Rezoning Transportation Analysis

Petition Number: 2022-147

Revision Log:

Date	Description
1-25-23	First Review (IW)
2-22-23	Second Review (IW)
03-22-23	Third Review (IW)
04-25-23	Fourth Review ZC (IW)

RZ-101

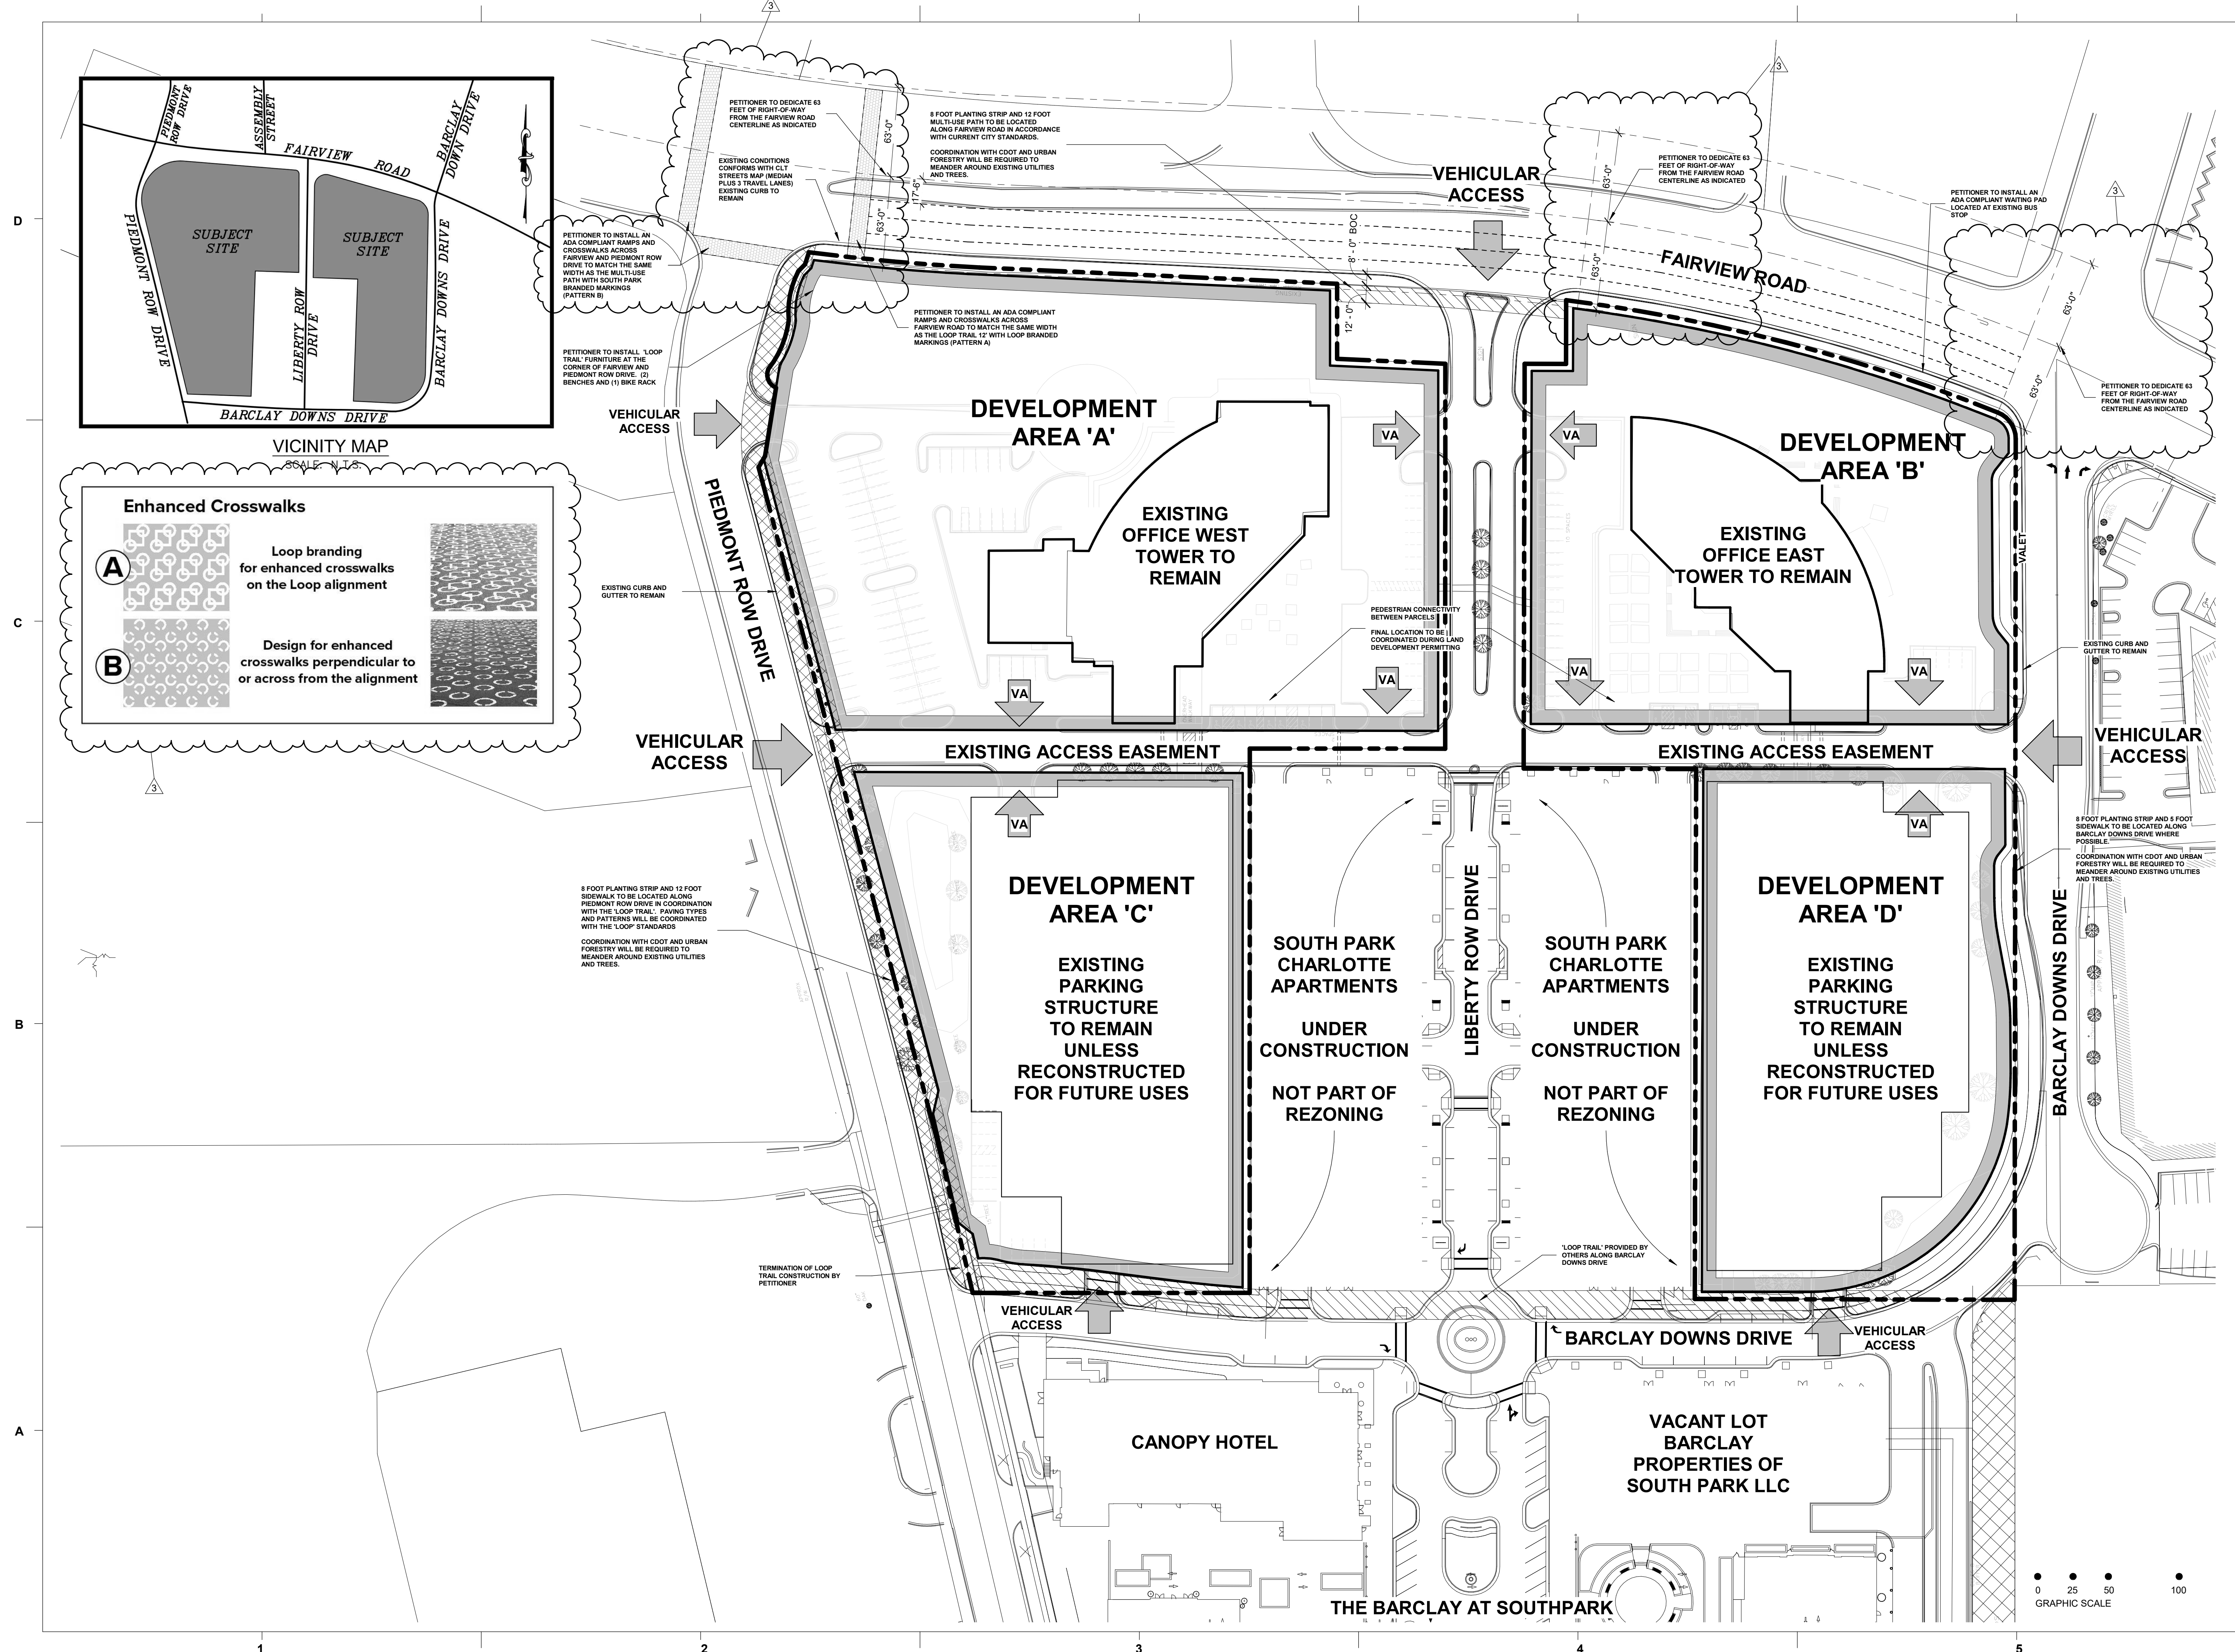
11. **New Comment 2-22-23:** ~~In order to comply with federal ADA requirements, the ramps and crosswalk(s) across Fairview Road and Piedmont Row Drive will need to be reinstalled so that the width is the same as the Multi-Use Path(s) the petitioner has agreed to install. A note should be added to install the crossing across Fairview Road with Loop Brand crosswalk markings.~~

Clarifying Comment 3-22-23: ~~Update conditional note V.d.ii.iii. to change "WB" to "EB" as the southern crosswalk is along the eastbound direction on Fairview Road.~~
